KIRKLEES METROPOLITAN COUNCIL INVESTMENT & REGENERATION SERVICE

DELEGATED DECISION TO DETERMINE PLANNING APPLICATIONS

Reference No:	2025/62/91380/E
Site Address:	21, Kertland Street, Savile Town, Dewsbury, WF12 9PU
Description:	Erection of first and second floor extension
Recommending Officer:	Jennifer Booth

DECISION - Refuse

Project:
 21 Kertland St,
 Dewsbury,
 WF12 9PU
 Client:
 Mr T Sadiq
 Drawing:
 Plans As Proposed
 Date: 10/05/25 Scale: 1:1250/1:200/1:100 Size: A1
 Drawing Number:
 23-006-41

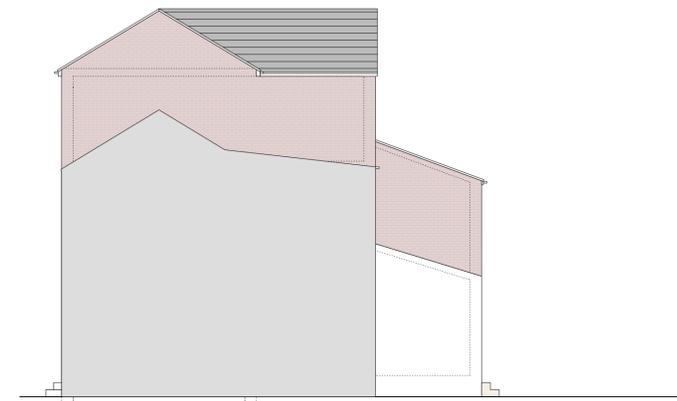
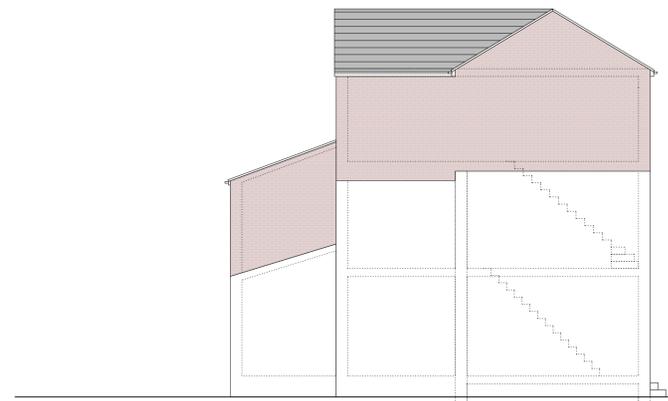
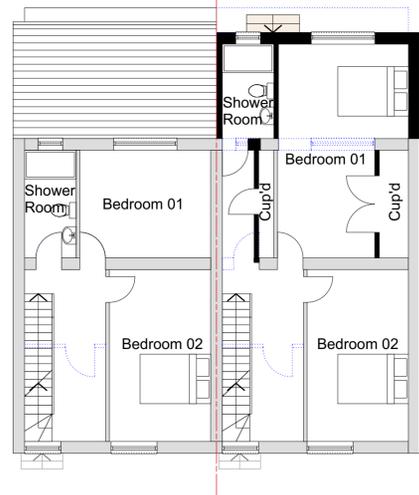
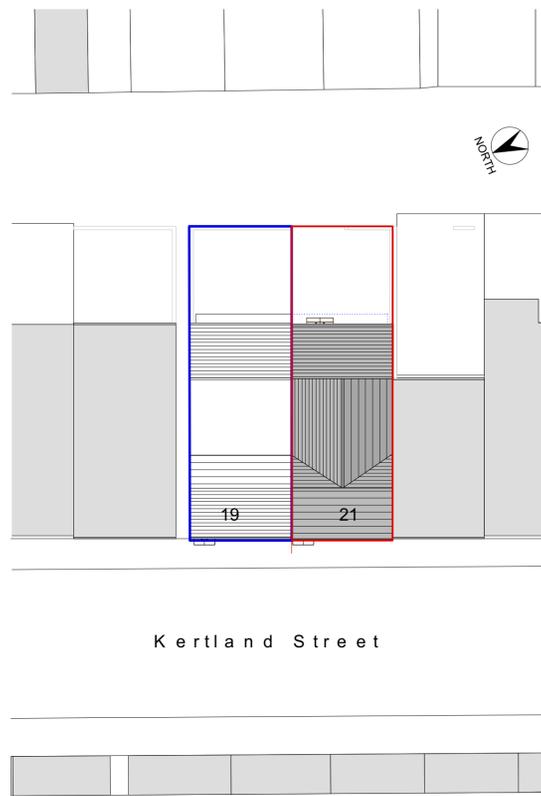
The eaves height of the dwelling would be increased from 6.1m to 9m with the overall height of the dwelling increasing from 8.1m to 11m. The roof pitch would be retained over the original house and a perpendicular pitched roof over the two storey rear extension.

It is appreciated that the character of Savile Town is very urbanised, with older terraced properties which have been substantially extended to the rear and within the roof scape. However, the properties on Kertland Street maintain the height of the established terrace row at approximately 8m above the pavement level even with the existing roof alterations. The proposals would see the host property rise another 3m above the row which would form an incongruous feature.

Kirklees have adopted the House Extension and Alterations Supplementary Planning Document (SPD), which places emphasis through principles KDP1 and KDP2 on the character of the host property and the wider area. The supplementary document carries significant weight in the determination of planning applications. There is no current fall back such as potential under the General Permitted Development Order (GDPO) given the age of the property. Furthermore, the lack of any similar extensions to the properties within this row of properties on Kertland Street (which may have provided justification for such development contrary to current policy) is such that the raising of roof of the property would be out of character with the immediate uninterrupted terrace building group. As such, the upwards extension proposed given the scale and height, would not be acceptable in terms of visual amenity.

The first floor extension would be similar in appearance to the existing extension to the rear of the adjacent dwelling and would not require any increase in terms of the footprint. The first floor extension would have the potential to be supported subject to an appropriate roof design in terms of visual amenity.

Having taken the above into account, the second floor extension would result in harm in terms of visual amenity for both the host dwelling and the wider street scene, thereby failing to comply with Policy LP24 of the Kirklees Local Plan (a) in terms of the form, scale and layout, KDP 1 & 2 of the House Extensions & Alterations SPD and the aims of chapter 12 of the National Planning Policy Framework.

The proposed raising of the roof, due to the design and height, would appear out of character with the host property and the neighbouring dwellings within this row. Furthermore, the overall bulk and massing of the extension would not appear subservient to the original building and would therefore not promote good design. To permit the proposals would be detrimental in terms of visual amenity and contrary to policy LP24 of the Kirklees Local Plan, KDP1 & KDP2 of the House Extensions & Alterations SPD and advice within chapter 12 of the National Planning Policy Framework.

1. The proposed raising of the roof, due to the design and height, would appear out of character with the host property and the neighbouring dwellings within this terrace row. Furthermore, the overall bulk and massing of the extension would not appear subservient to the original building and would therefore not promote good design. To permit the proposals would be detrimental in terms of visual amenity and contrary to policy LP24 of the Kirklees Local Plan, KDP1 & KDP2 of the House Extensions & Alterations SPD and advice within chapter 12 of the National Planning Policy Framework.
